Technical design note

Project name	Nestle Block B		
Design note title	Flood Risk response to LLFA		
Document reference	C-01669_TN-C-0100		
Author	GJ		
Revision	PO1		
Date	18 October 2023	Approved	☐

The purpose of this technical note is to provide clear responses and supporting information for Hillingdon Planning and Regeneration in regards to flood risk queries from the LLFA concerning Nestle Block B.

DRAWING TITLE
Roof type scoping plan

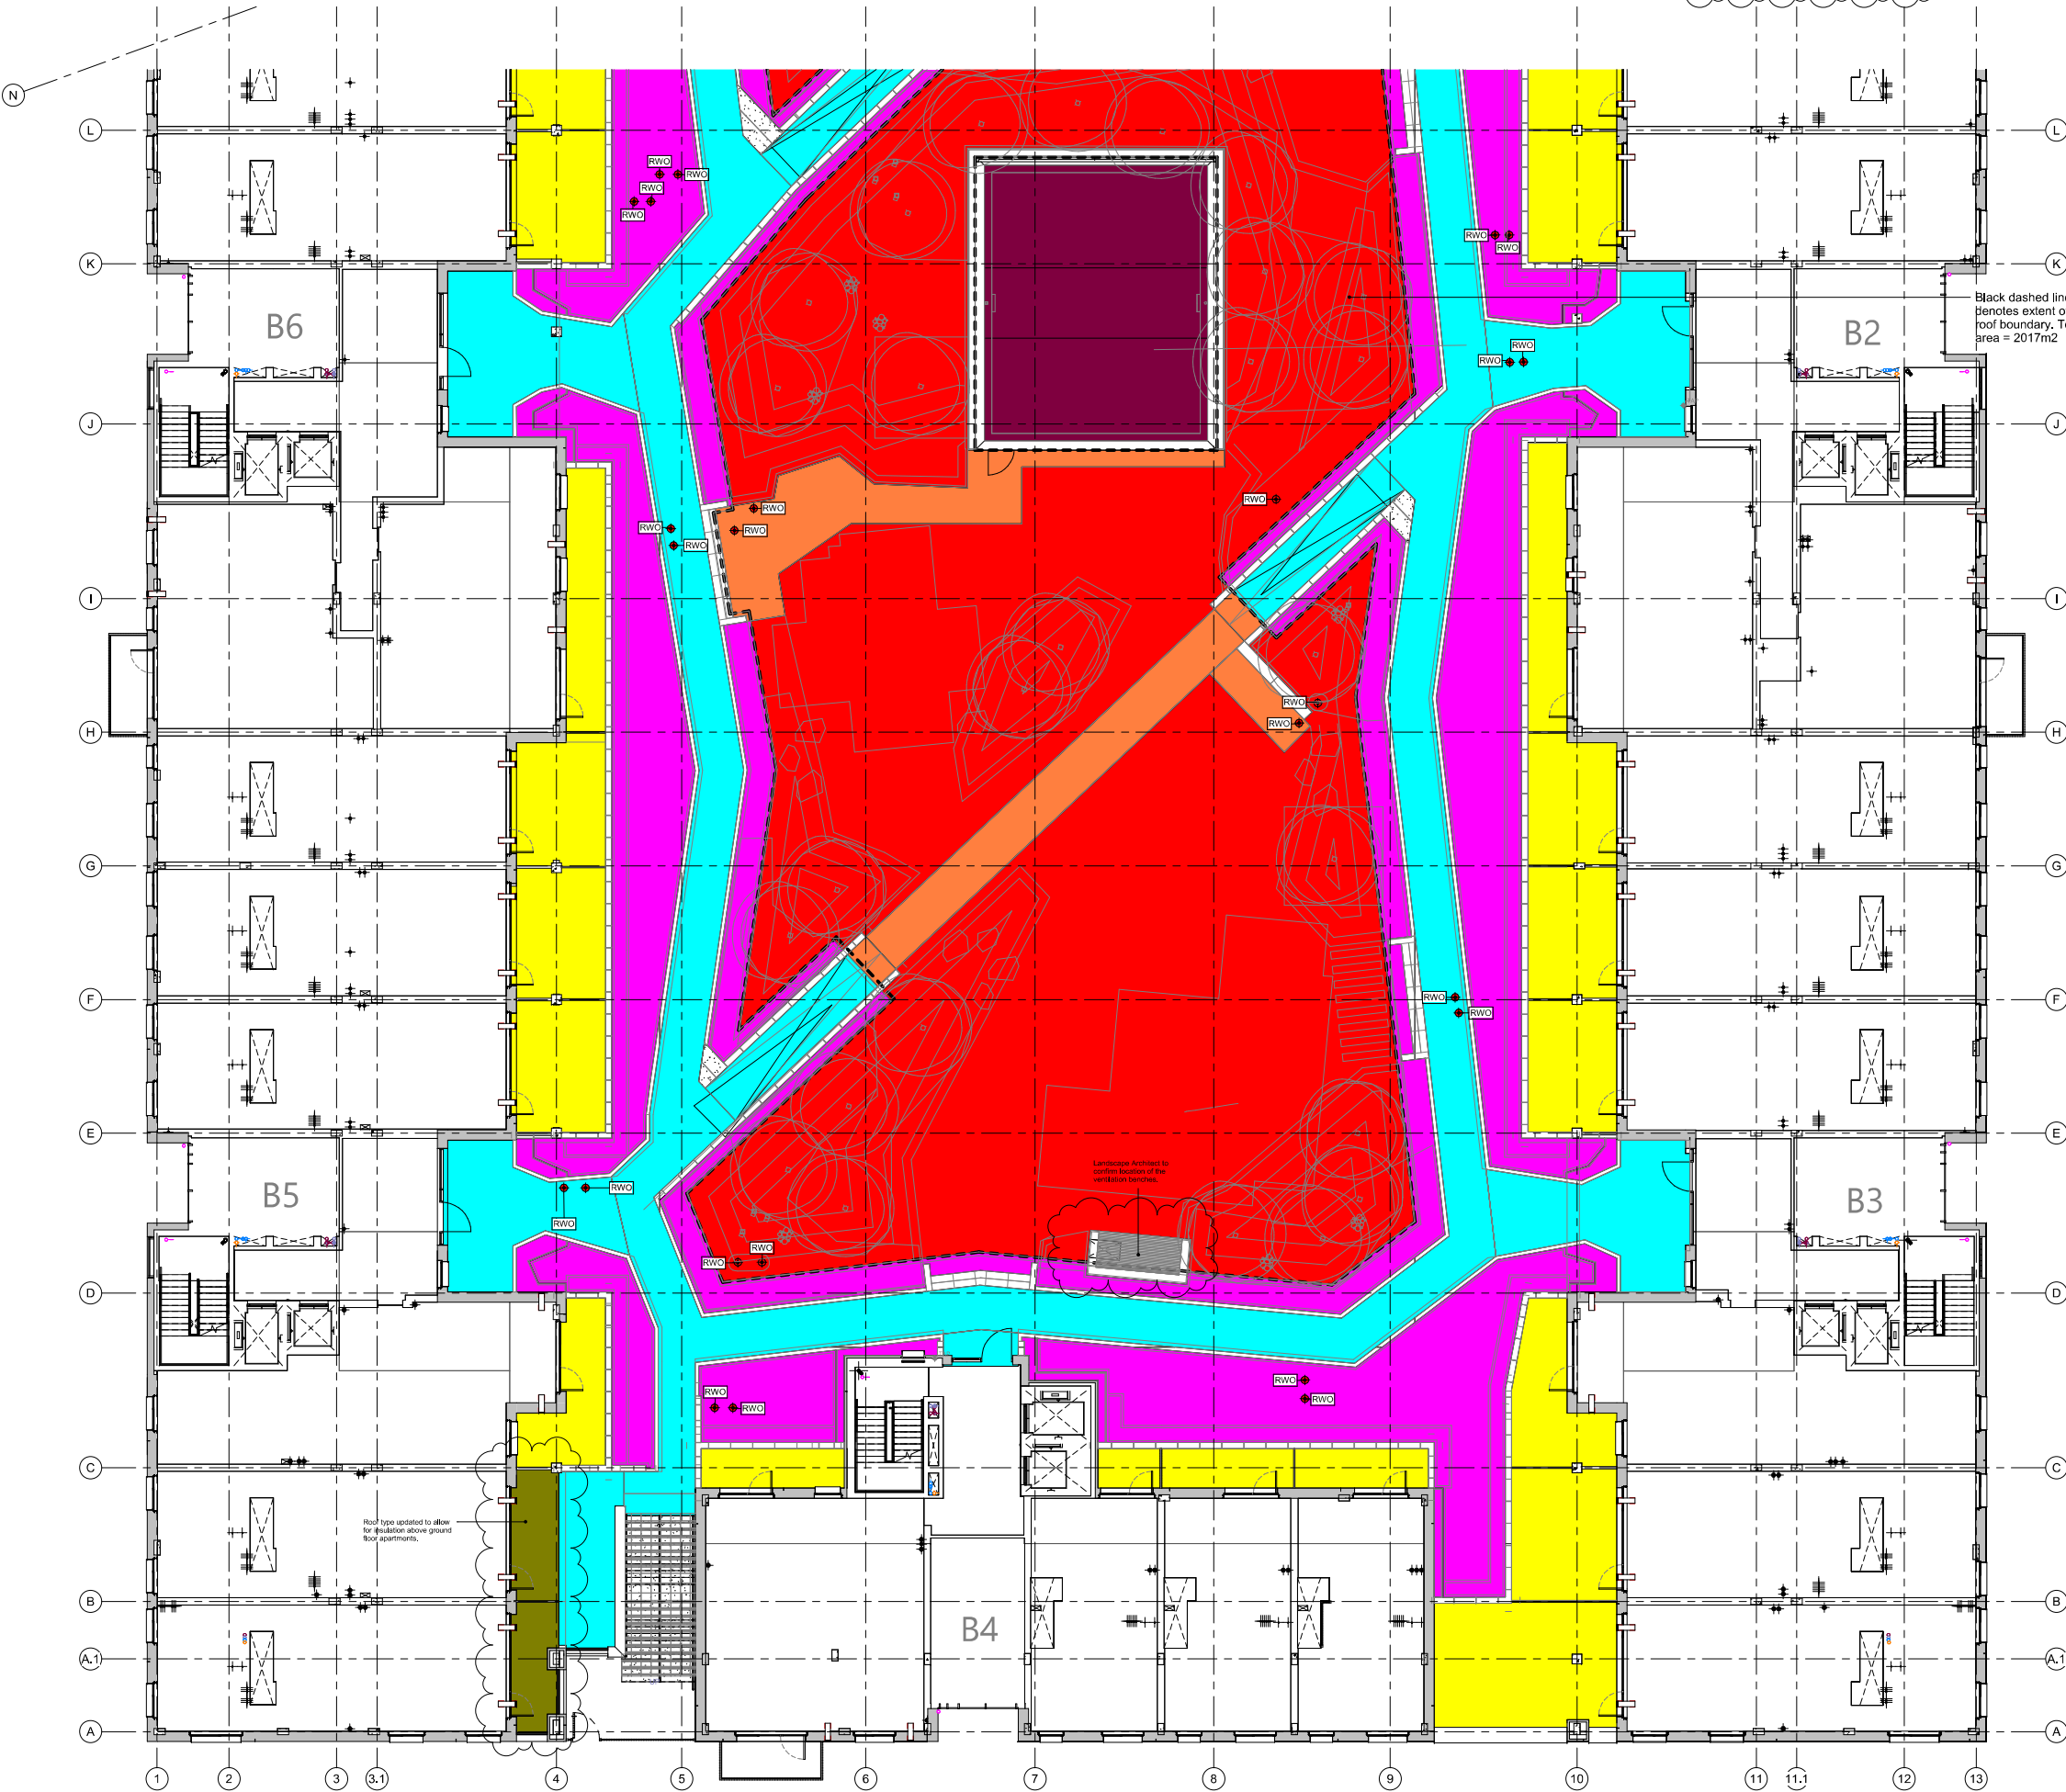
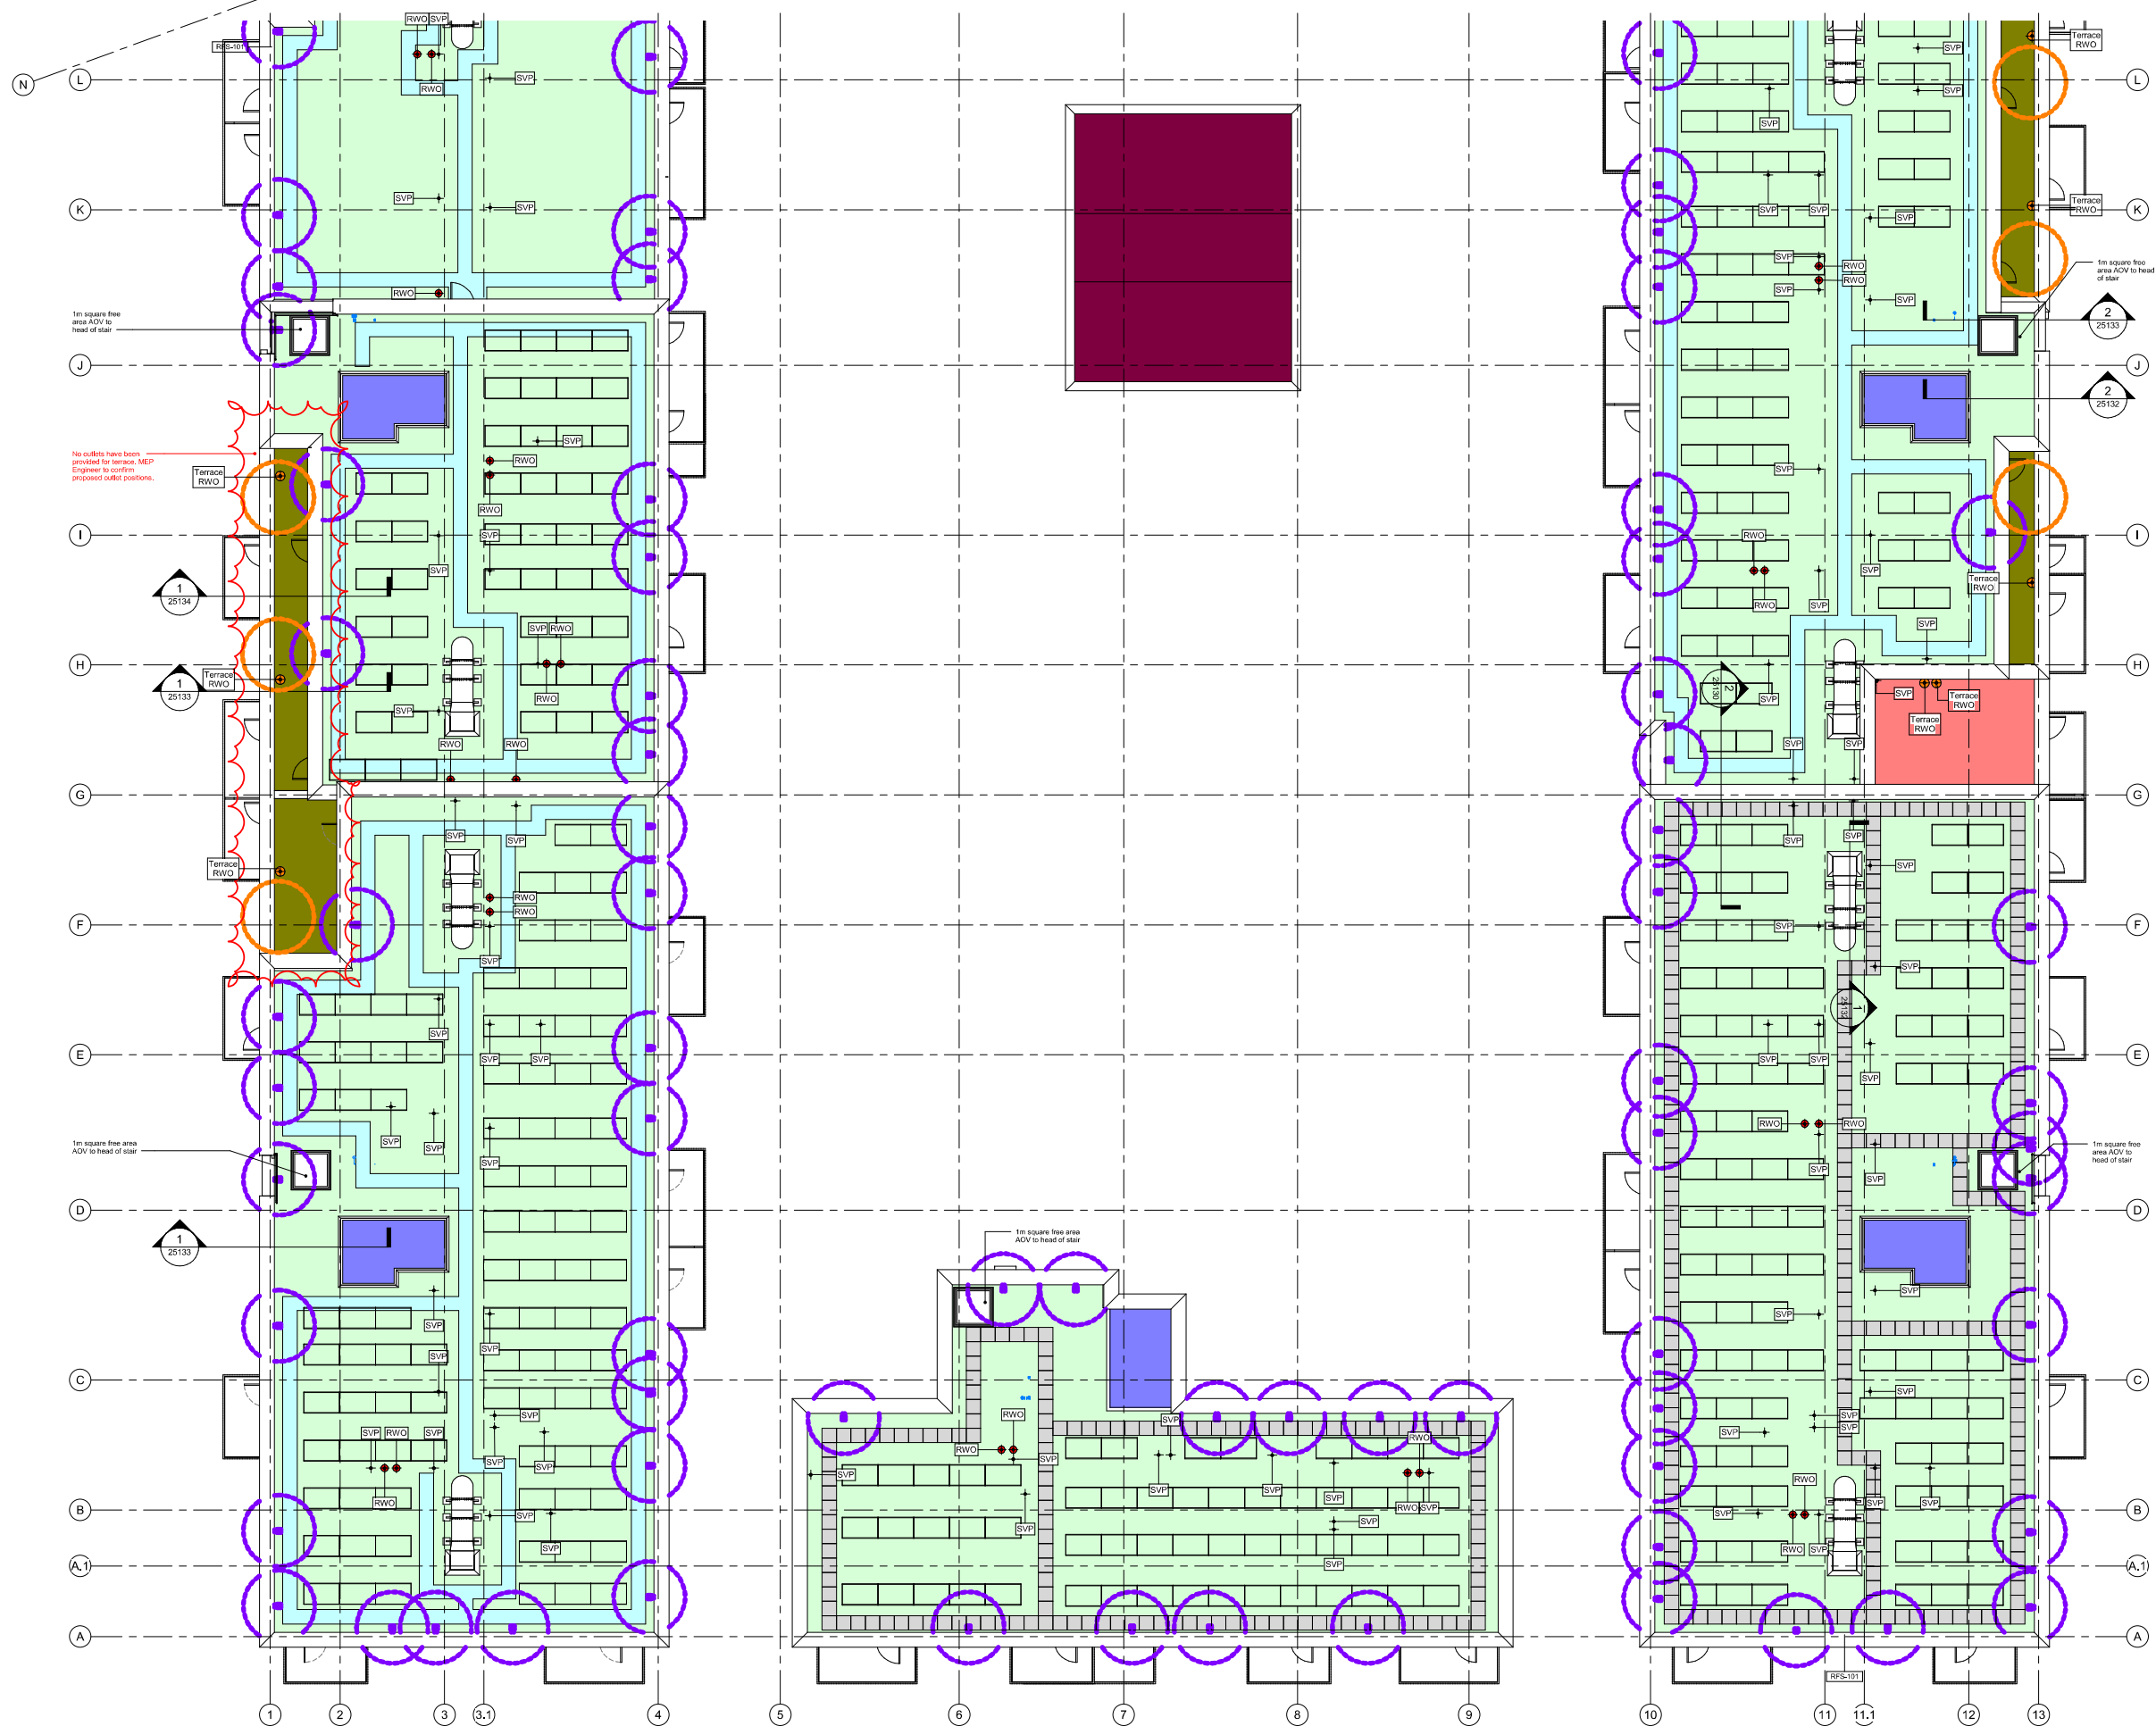
Includes the blue and green roofs in the Drainage Layout Sheets for Block B.

The blue roof locations have been detailed on Chapman Taylor Architects drawings. Refer to layouts NFH-CTA-B-27-X-01-DR-A-27101 to 27112. The blue roof system extents are across the majority of available roof space. Refer to appendix D
